My reference: 3/2025/0270

Date: 21 May 2025

Location: Lower Reaps Farm Whinney Lane Mellor BB2 7EL

Proposal: Approval of details reserved by conditions 3 (materials), 4 (window and door specifications), 5 (details of roof lights), 7 (building recording and analysis), 11 (electric vehicle charging point), 13 (landscaping) and 17 (drainage) of planning permission 3/2022/1165.

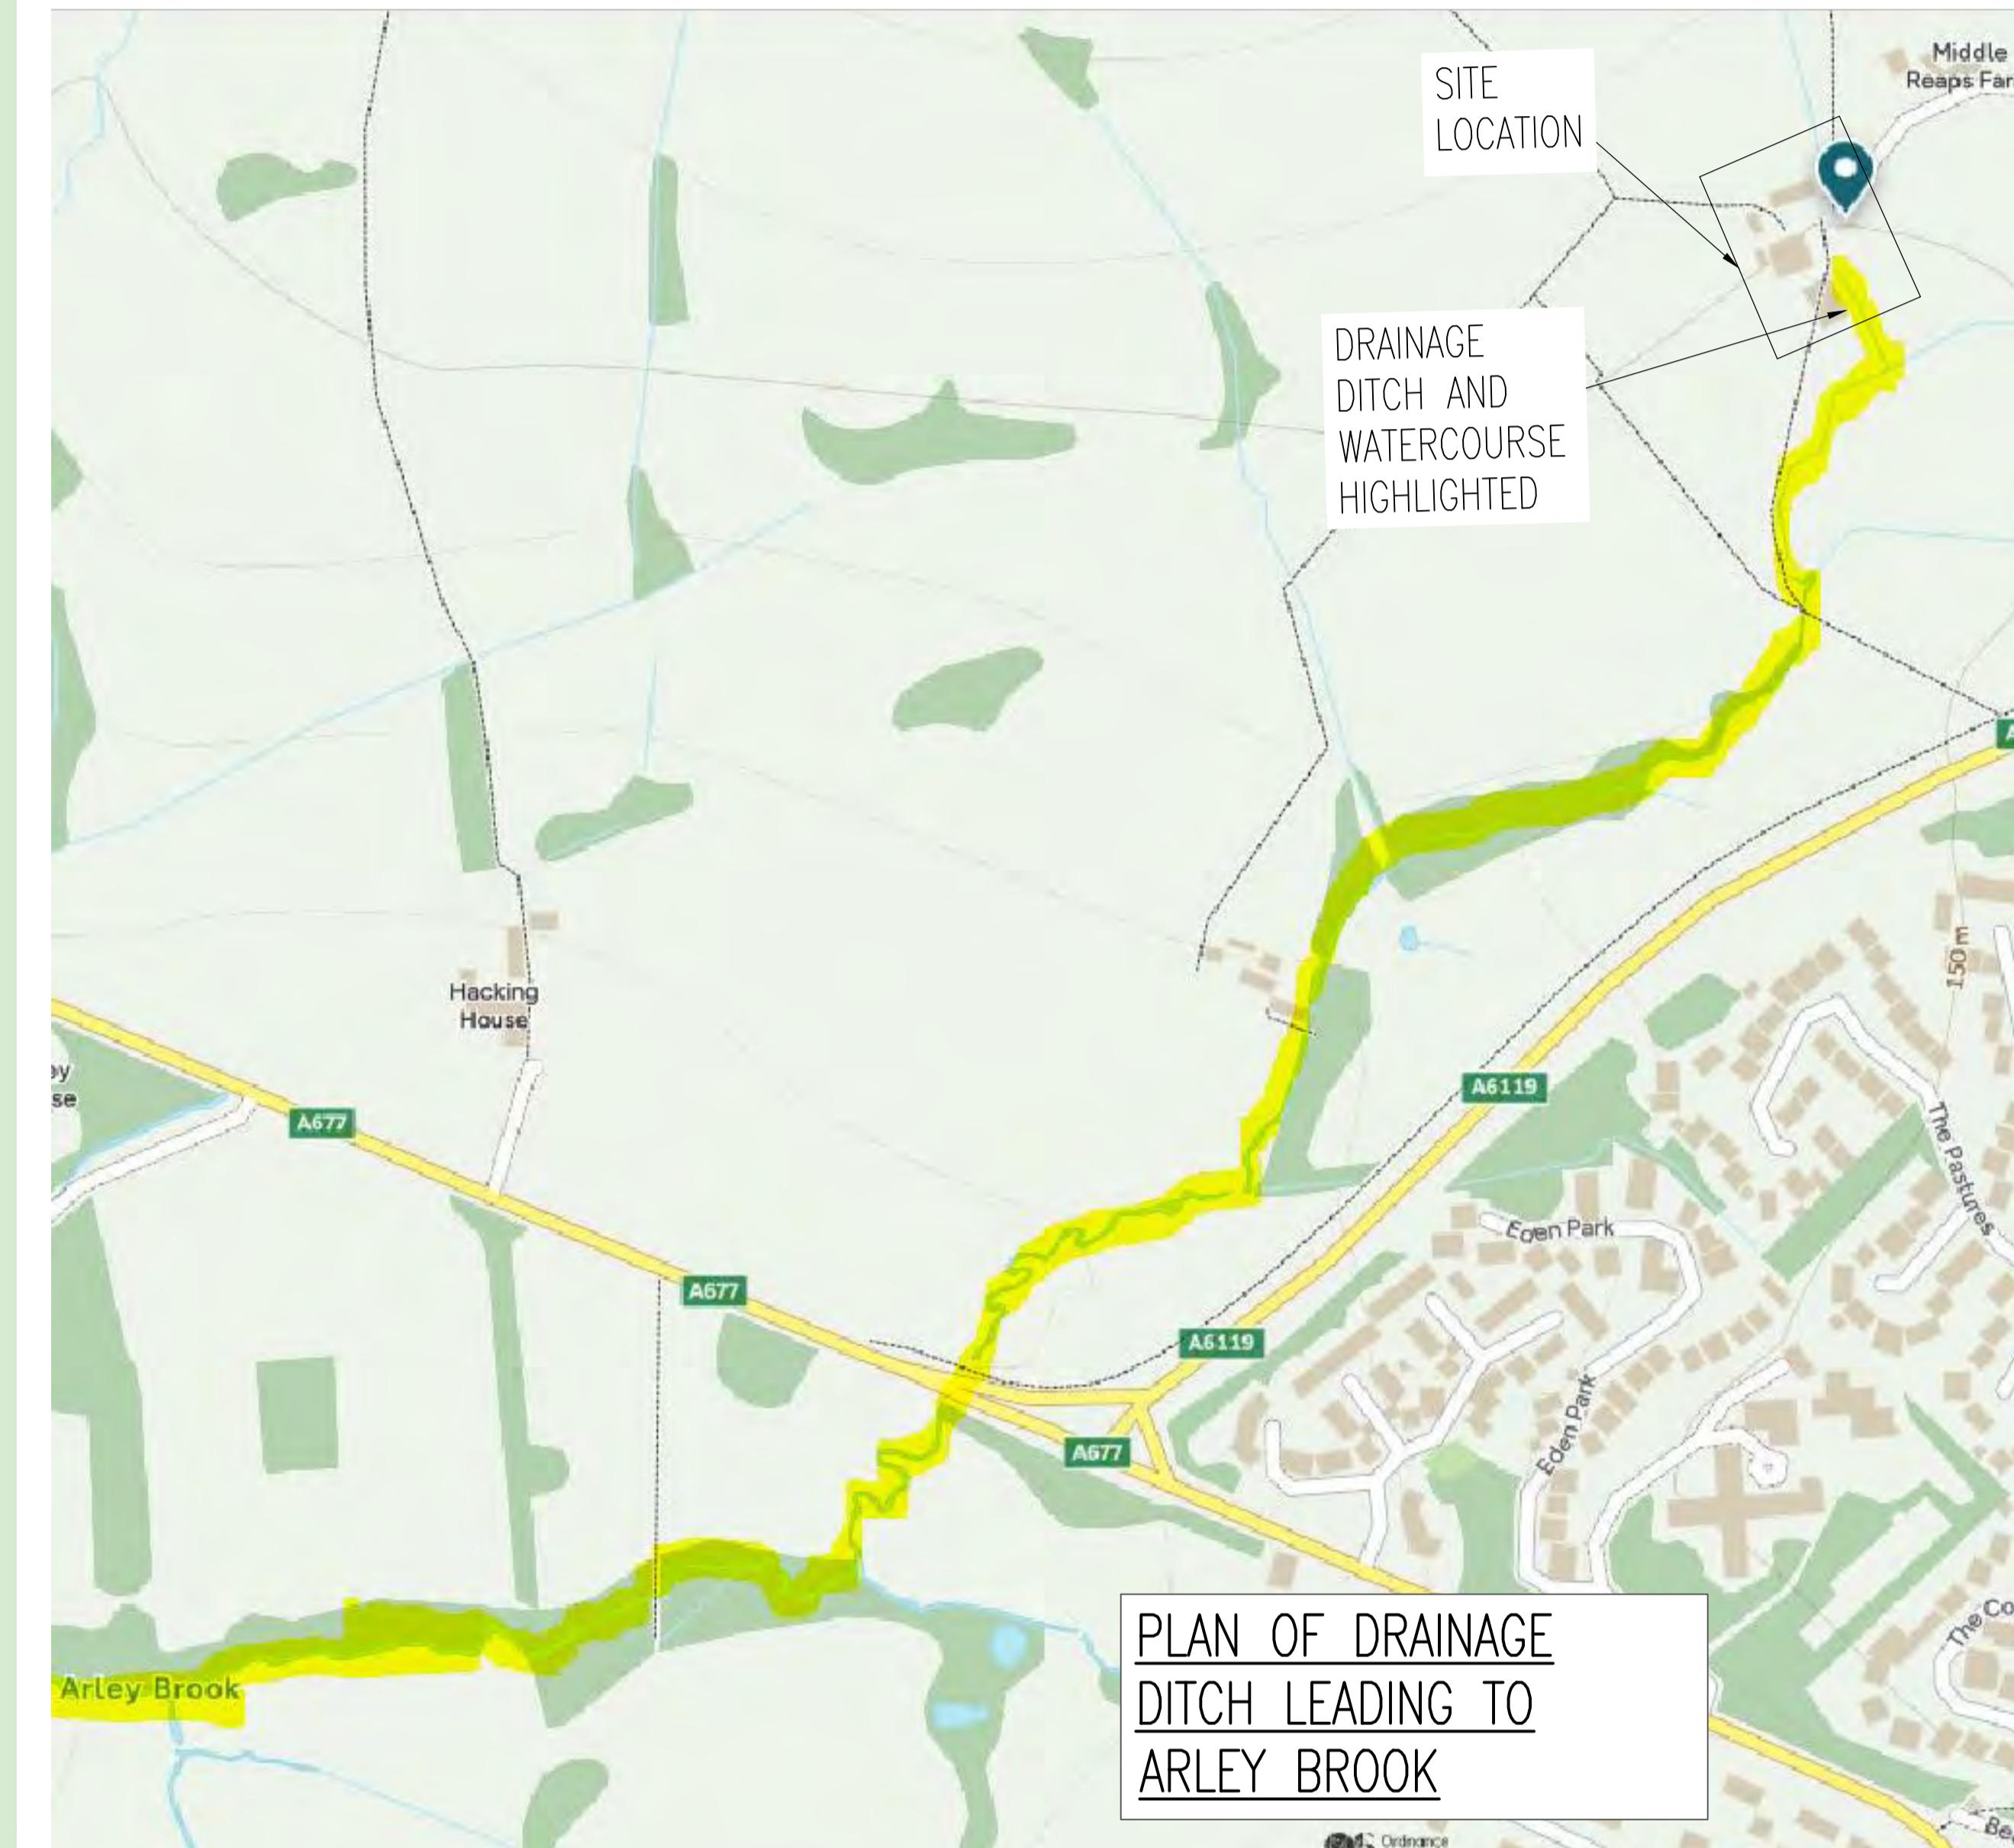
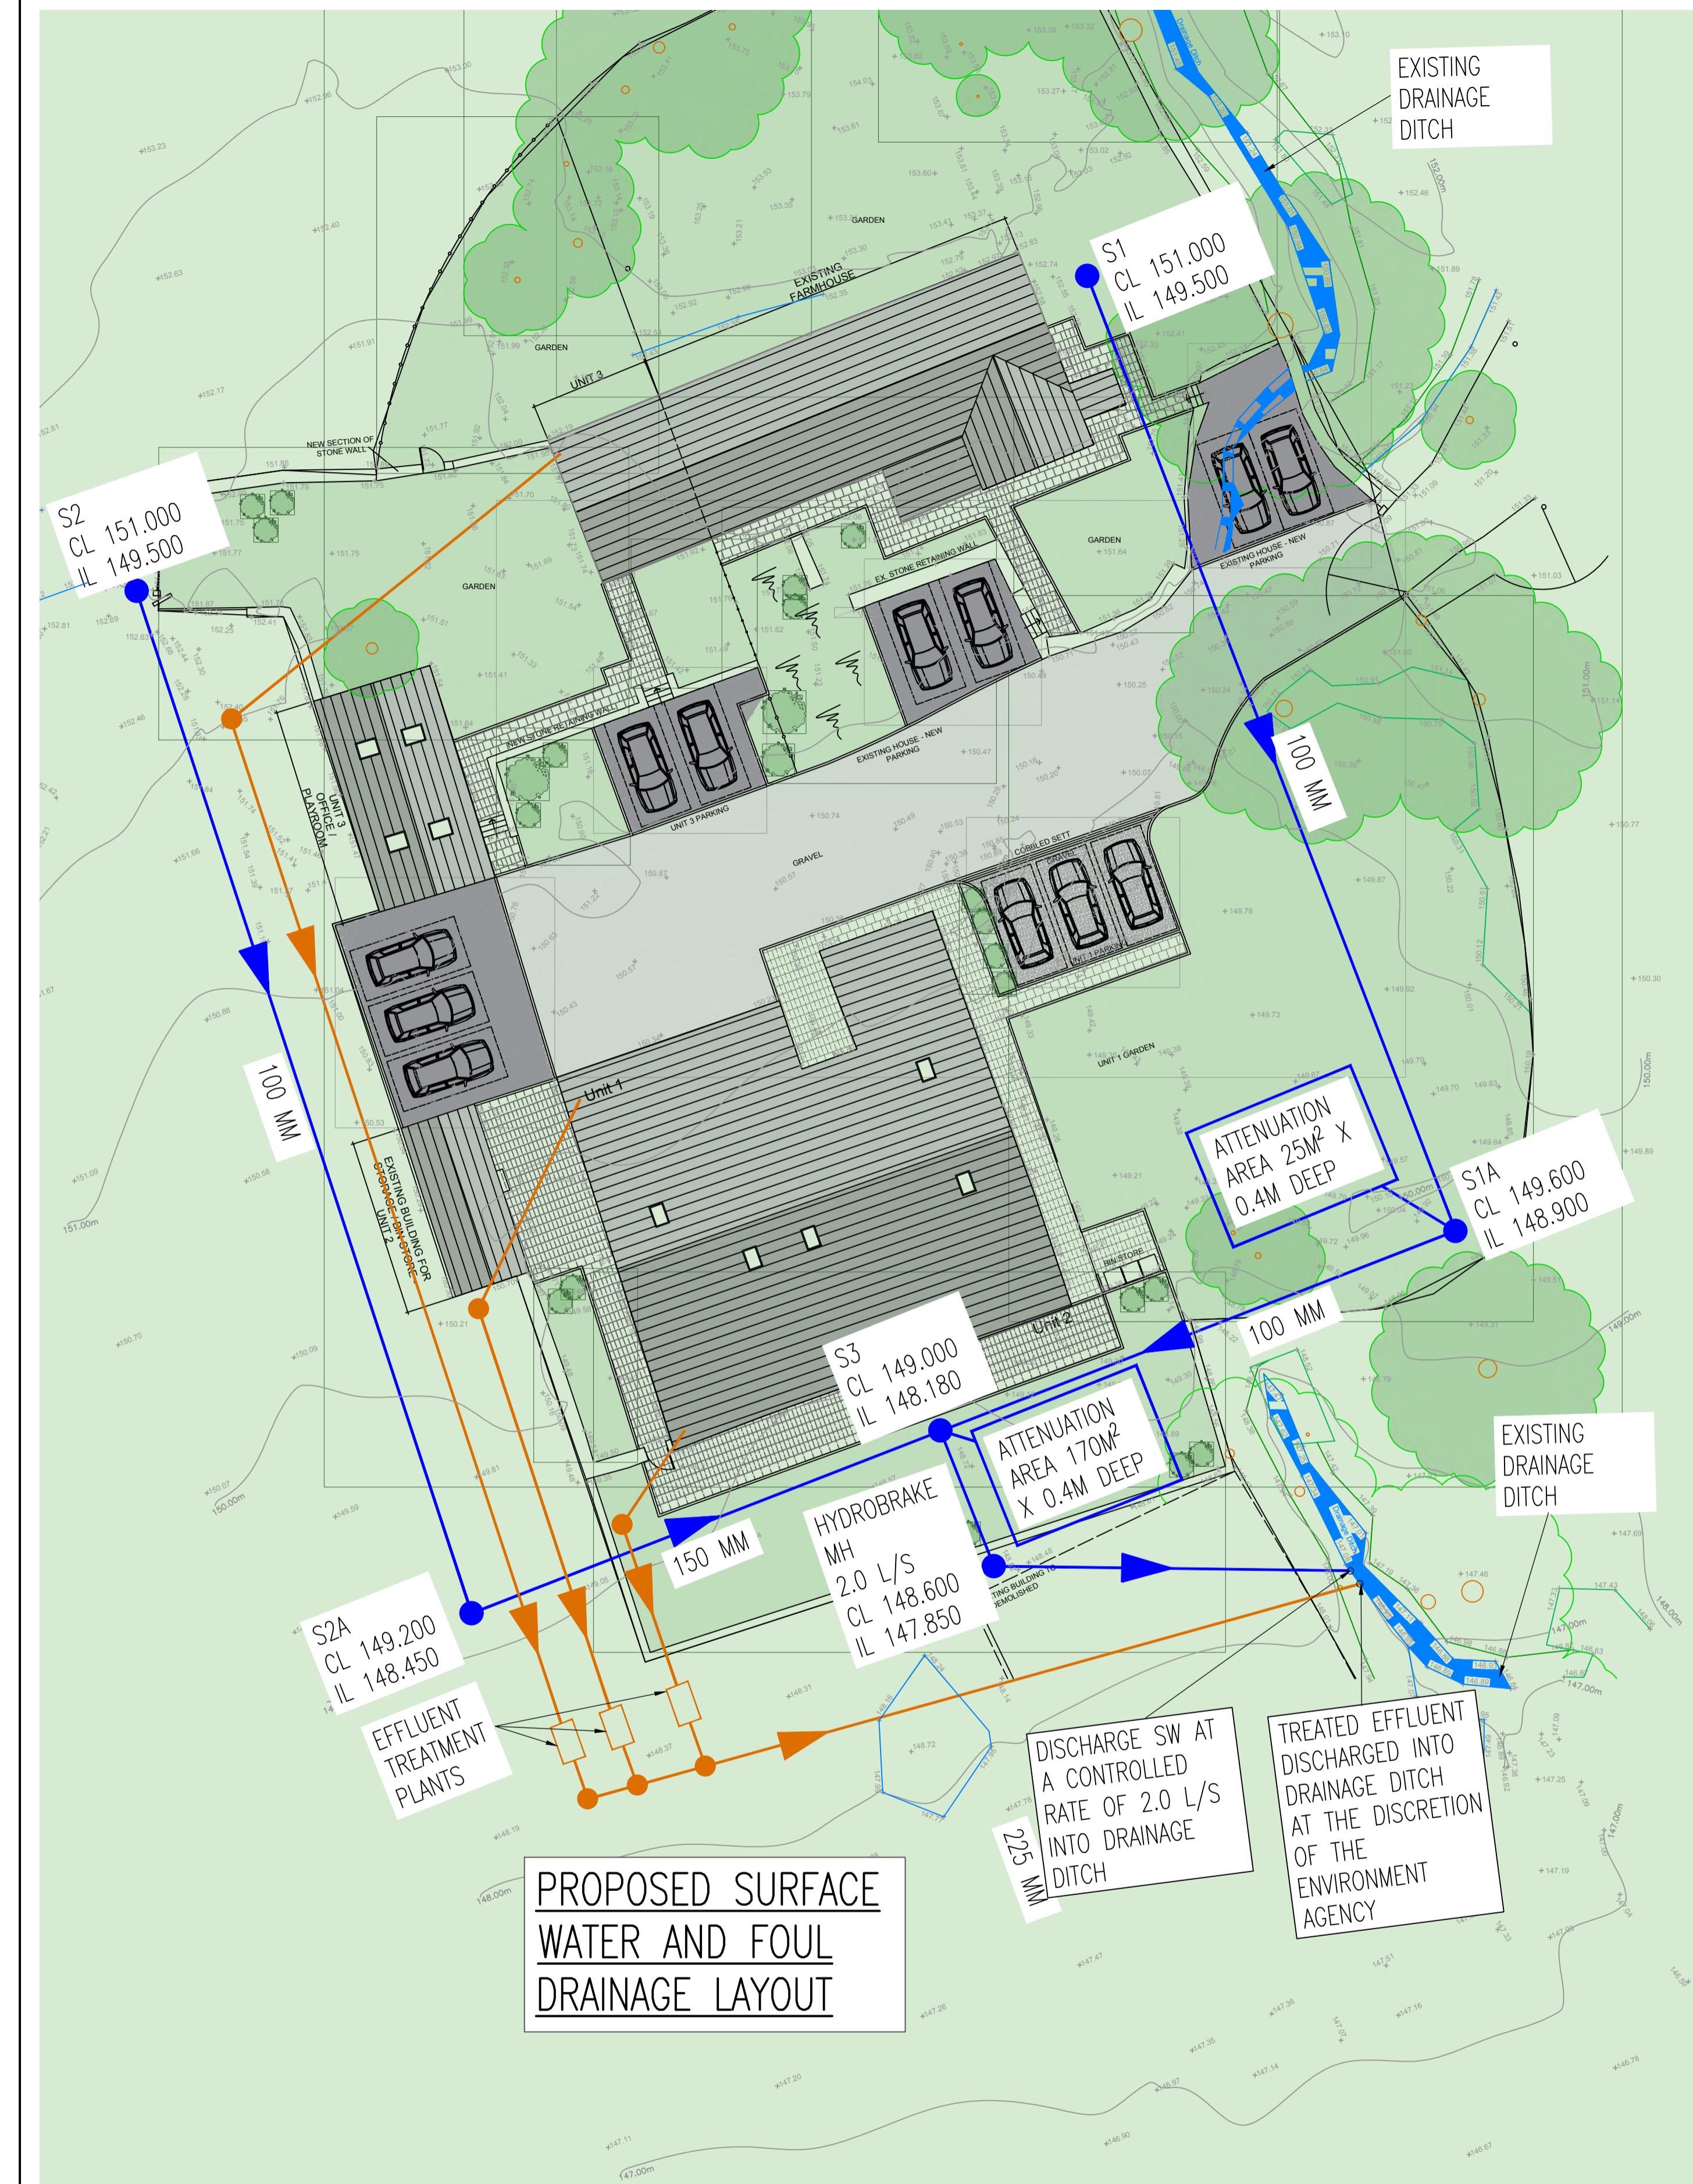
Condition 17 (drainage) – The submitted Surface Water and Foul Water Drainage Strategy by Reid Jones Partnership Ltd dated March 2025 identifies that surface water runoff from the developed site will be attenuated and discharged into the existing drainage ditch, which flows from the northern to the southern boundary before continuing to Arley Brook, maintaining the natural drainage pattern. The discharge rate will be restricted to greenfield run off rate of 2.0 l/s and the surface water drainage design accommodates

runoff from all rainfall events up to the 1-in-100-year critical storm, with a 45% allowance for climate change. Attenuation is achieved through underground storage crates within the soft landscaped areas to the south of the converted buildings. In addition, foul water from the three proposed buildings will be treated by separate treatment plants before being discharged into the drainage ditch. This is considered to be acceptable as the condition required that surface water does not discharge into the public sewer. Condition 17 is partially discharged insofar that no dwelling shall be occupied or brought into first use until the drainage works associated with that dwelling have been completed in accordance with the approved scheme and the agreed scheme shall be retained, managed and maintained in accordance with the approved details.
